From: Andrew Wood
Sent: 26 February 2019 17:40
To: Planning.Responses
Subject: FW: Planning Application FG/220/18/PL : Land adjacent to Elm Lodge, Tamarisk Way, Ferring, West Sussex BN12 5ER

RE: Planning Application FG/220/18/PL : Land adjacent to Elm Lodge, Tamarisk Way, Ferring, West Sussex BN12 5ER

Laura Gibbons, MEng, GMICE
Engineer (Drainage & Coastal)

PROPOSED INDICATIVE PART
FOUNDATION SECTION DETAIL 1:50.

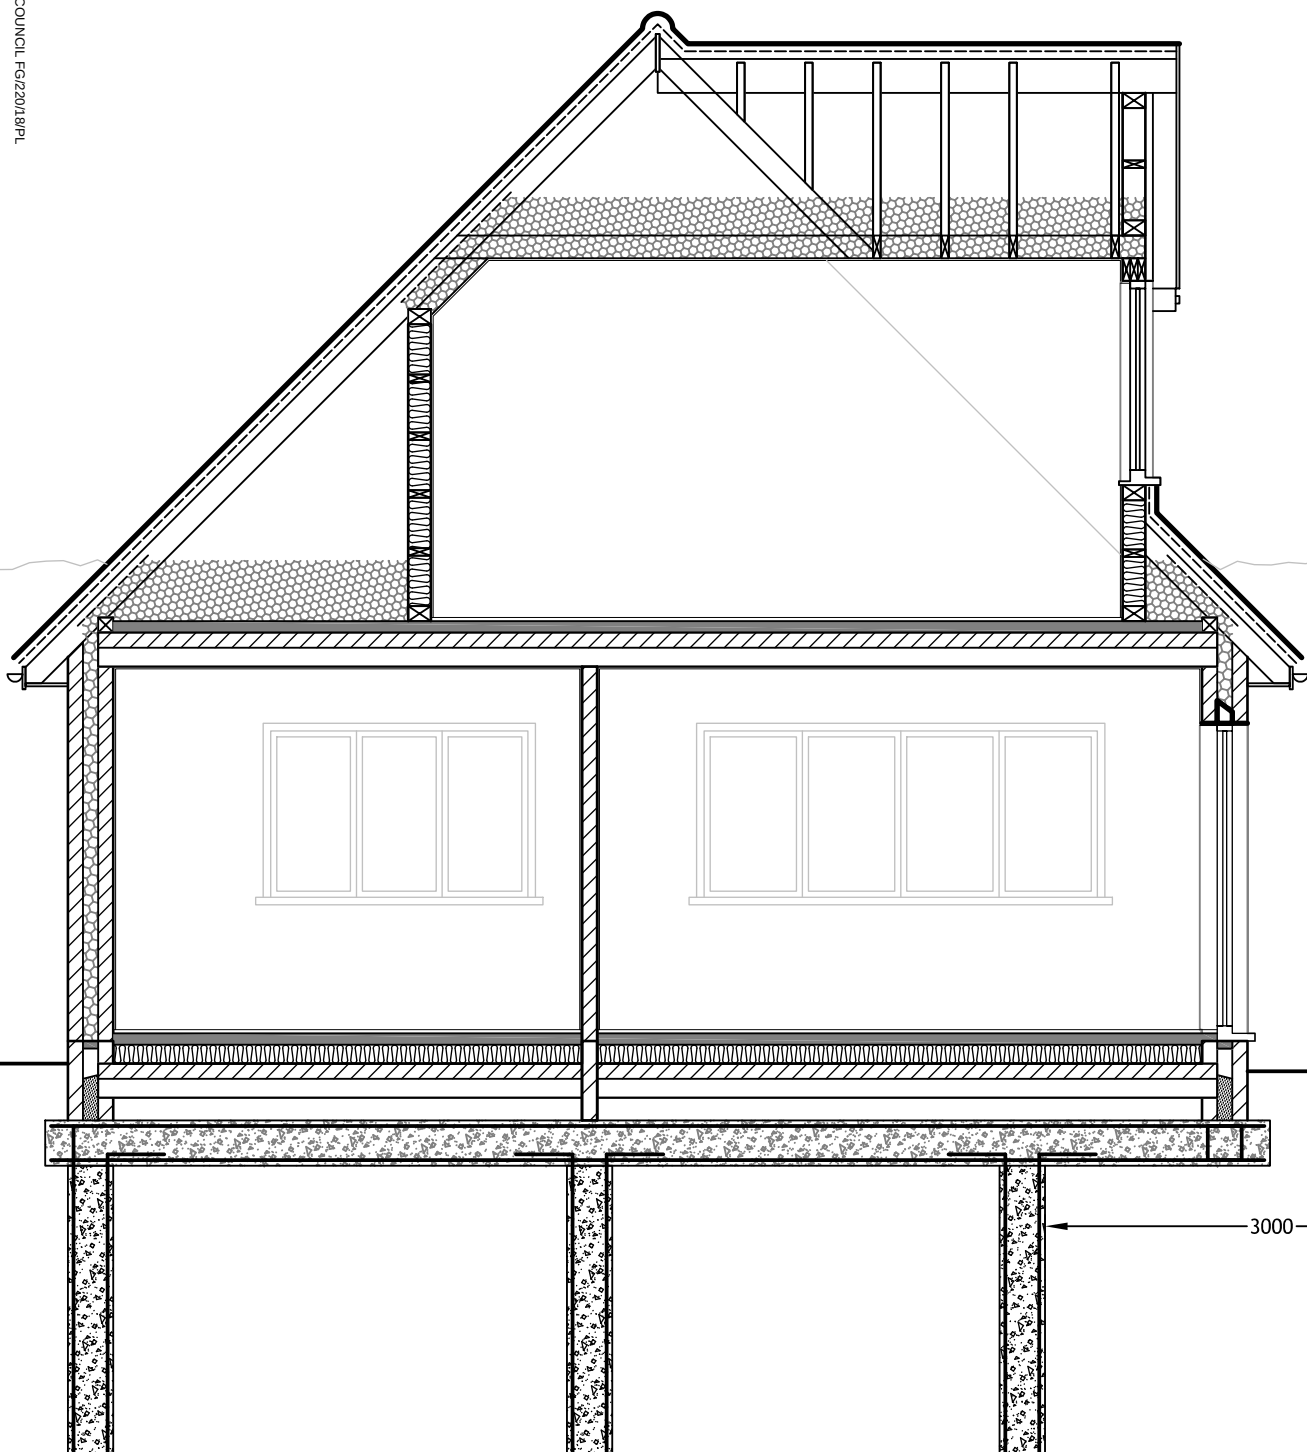
2. I am not keen to see the building go up to within 0.8m of the pond. Access and erosion are both a concern. I would therefore be keen to see the building layout revised to provide more easement. As shown on the proposed indicative part foundation section detail, short bore piles would be positioned a minimum of 3m from any edge of the pond, reducing the risk of erosion by eliminating trench foundations. Given a specialist would be designing the reinforcement/camp shedding for the existing edge of the pond (again, to be agreed with ADC by condition prior to commencement), this would ensure there will be no erosion. Given the building would only be cantilevered at one point within 0.8m of the pond, there is still a large area of access around the east and all other parts of the pond. We note that ADC has never had to access the pond to carry out any maintenance works to date, therefore query why there is such an onerous requirement for access now. We also note that ADC cannot currently access the pond with plant, since we have gates to the property and a further gate at the rear which would obstruct machinery from accessing our garden to carry out any maintenance works at all. ADC would have greater access to the pond as a result of the proposal, given there would be no obstruction when entering from the driveway. ADC Bylaws state that "Riparian Owners are responsible for maintaining the watercourse and any associated structures (i.e. headwalls, screen, weir etc.) and primarily to keep them free of any obstructions that may impede flow in the watercourse". There will be no obstructions which impede the flow in the watercourse, as demonstrated. We can easily complete any pond works to ensure it is upgraded from its current state (which has not been identified as obstructed or badly maintained by ADC to date) before commencement of any building works on site. The bylaws state that "Arun District Council may decide to exercise the permissive powers if it is approached by property owners affected by badly maintained or obstructed watercourses and they have been unable to get a 'riparian owner' to carry out necessary works. In the first instance, Arun District Council will try to resolve the problem informally by explaining 'riparian ownership' responsibilities and agreeing the work that is required to the watercourse to rectify the problem. If this approach is unsuccessful, Arun District Council may require and enforce 'riparian owners' to carry out works using powers under S25 of the Land Drainage Act 1991 where the flow of water is impeded and the condition needs to be remedied." Given we as riparian owners will be able to access the pond from all sides to carry out any works in accordance with the bylaws, we do not understand why ADC would need access to our land, particularly from multiple different points given they cannot access it at all at present. It is the landowners (Riparian) responsibility to complete maintenance works, if we are informed of an impediment to flow we request landowners complete this maintenance. If they refuse to complete the work, we use our powers under S25, and this can be accompanied by forced entry through gates. The proposed layout will make it exceptionally difficult to complete maintenance. Irrespective of planning it is fairly evident that an impediment to flow is present, so we will be requiring you as landowners to complete maintenance to the pond to ensure silt levels are reduced and culverts are in an appropriate condition. Ongoing maintenance (including to any retaining walls) will be required after construction is complete, this is when the proposed site layout in my opinion would prevent this work.

We also attach an indicative proposed part foundation section detail to show proposed short bore piles a minimum of 3m from the edge of the existing pond. There will be no encroachment or structural implications for the pond.
